## EL PASO COUNTY STORMWATER MANAGEMENT PLAN CHECKLIST

EPC Project Number:

PROPOSED CUT & FILL

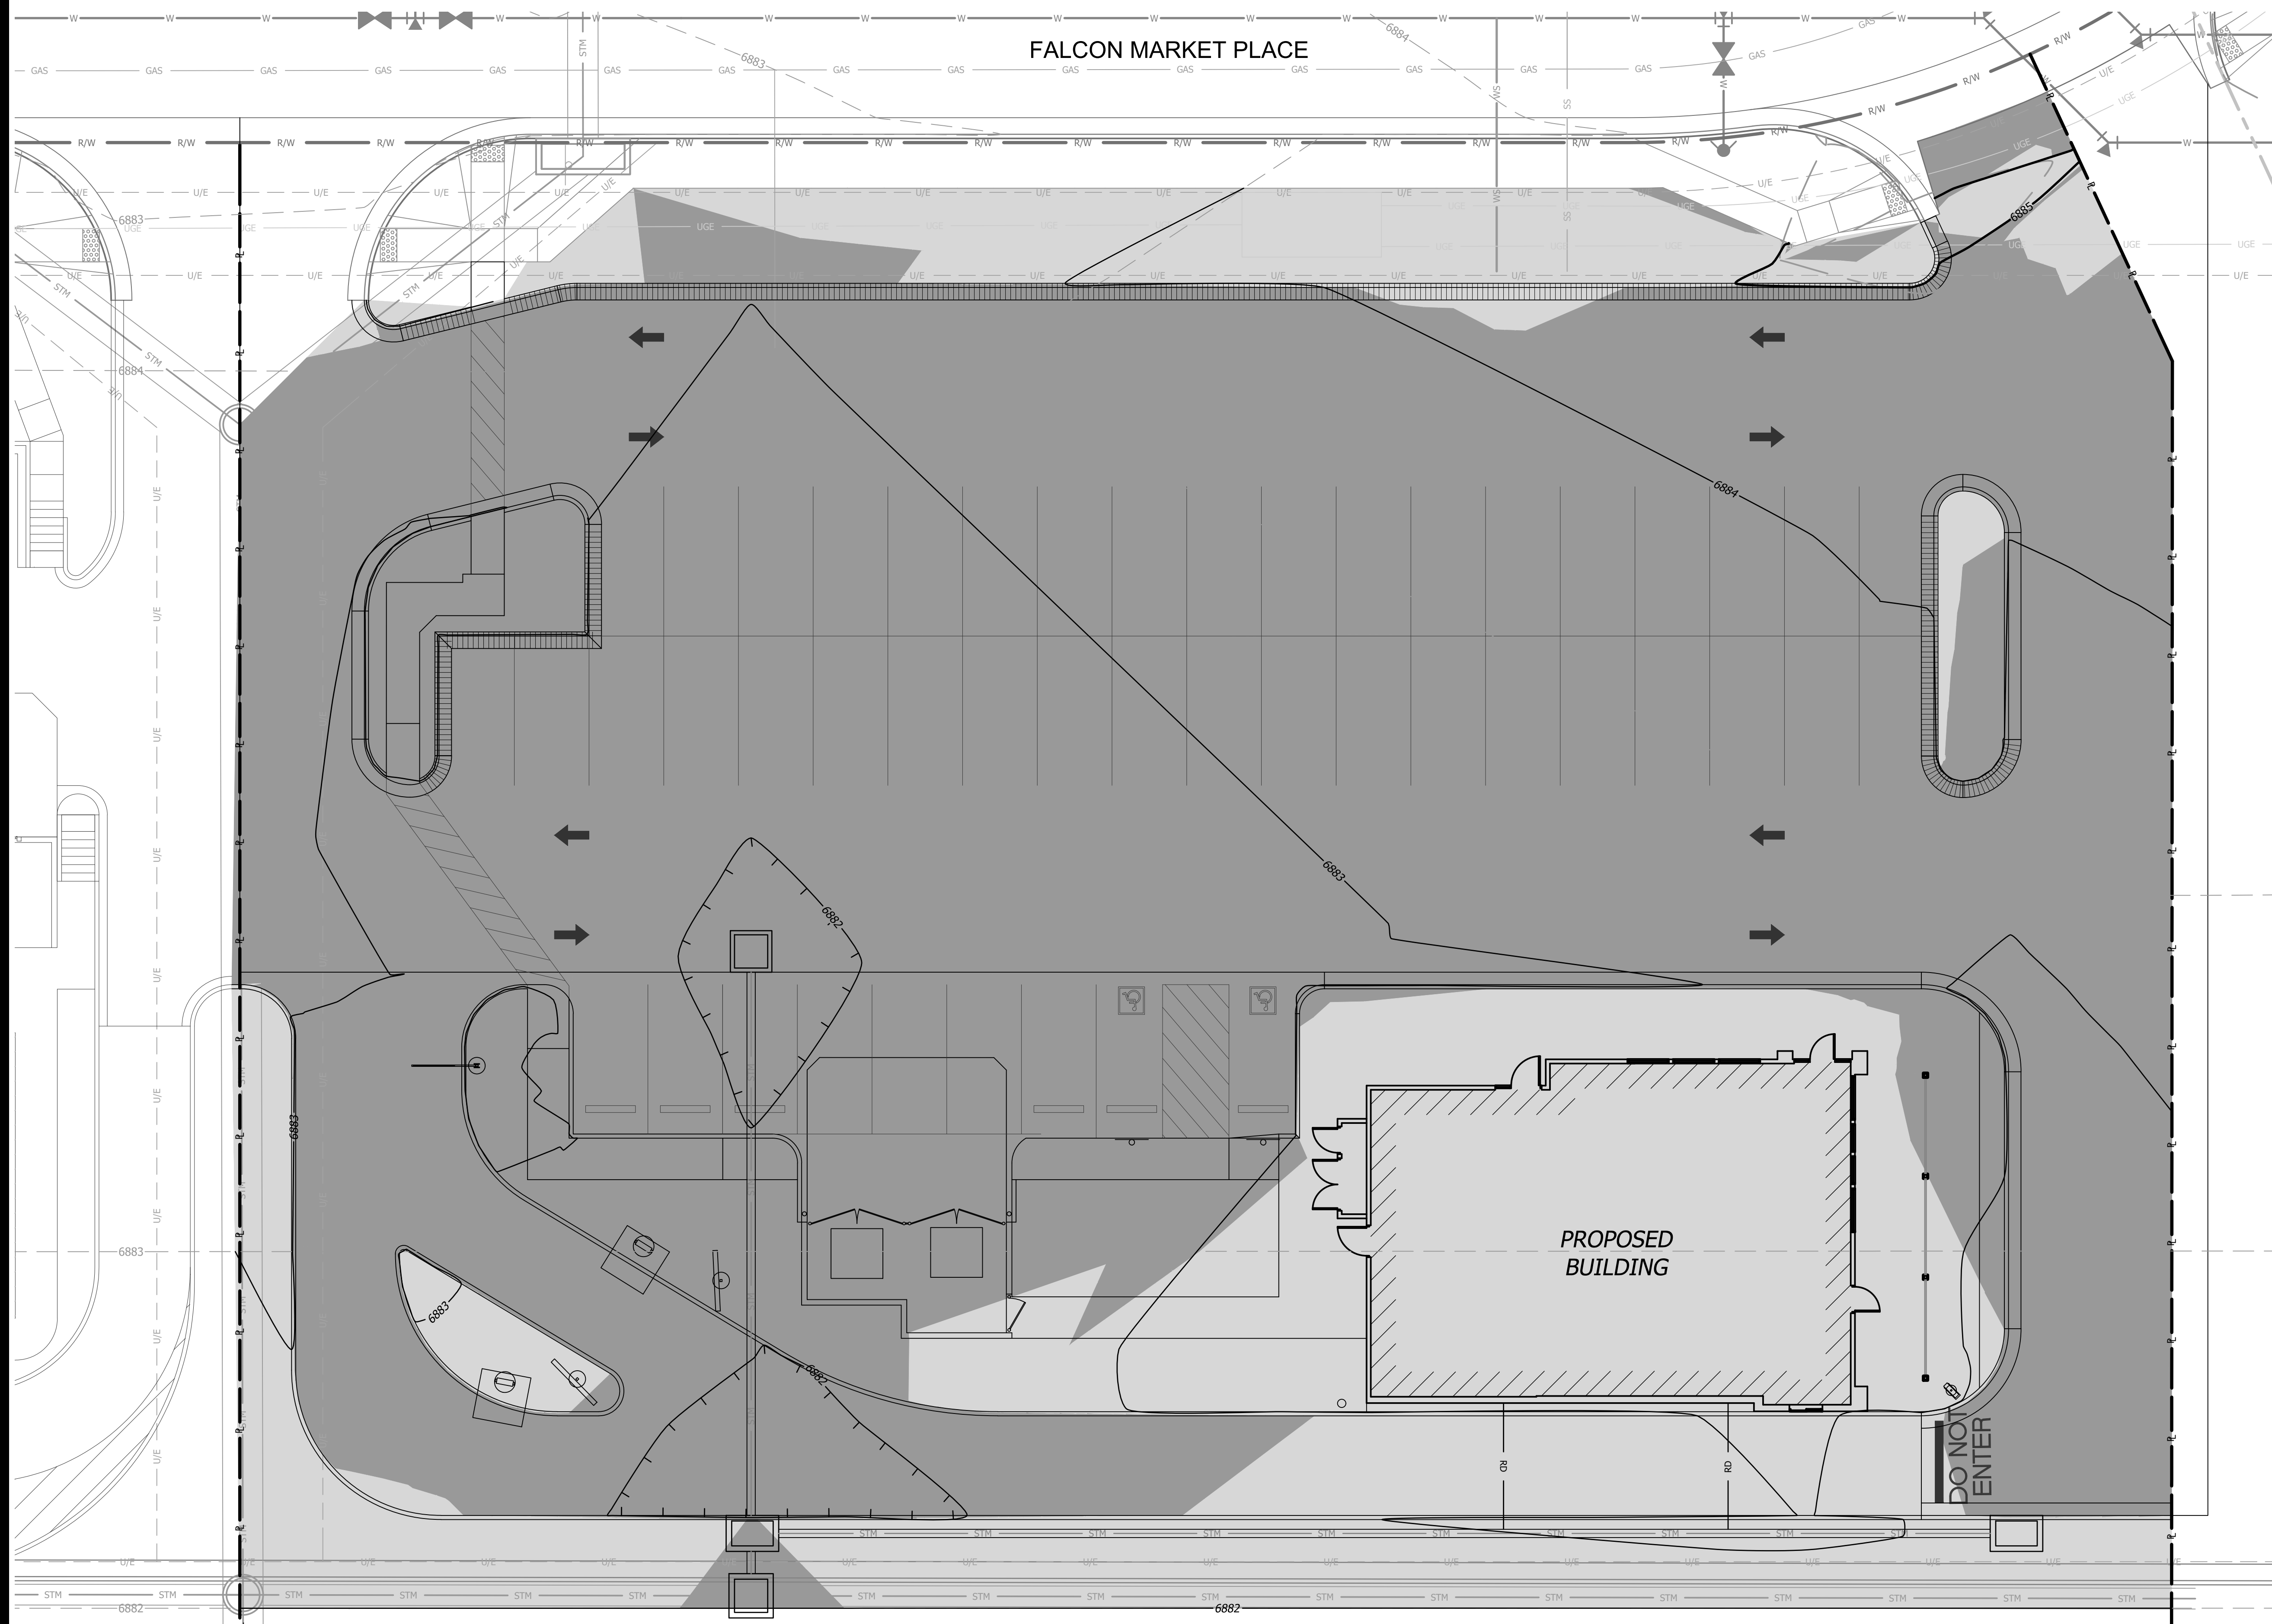
Applicant	EPC
17	SWMP Map to include:		
17a	construction site boundaries		X
17b	flow arrows to depict stormwater flow directions		✓
17c	all areas of disturbance		✓
17d	areas of cut and fill		X
17e	areas used for storage of building materials, soils (stockpiles) or wastes		✓
17f	location of any dedicated asphalt / concrete batch plants		X
17g	location of all structural control measures		X
17h	location of all non-structural control measures		✓
17i	springs, streams, wetlands and other surface waters, including areas that require maintenance of pre-existing vegetation within 50 feet of a receiving water		✓
18	Narrative description of all structural control measures to be used. Modifications to EPC standard control measures must meet or exceed County-approved details		✓
19	Description of all non-structural control measures to be used including seeding, mulching, protection of existing vegetation, site watering, sod placement, etc.		✓
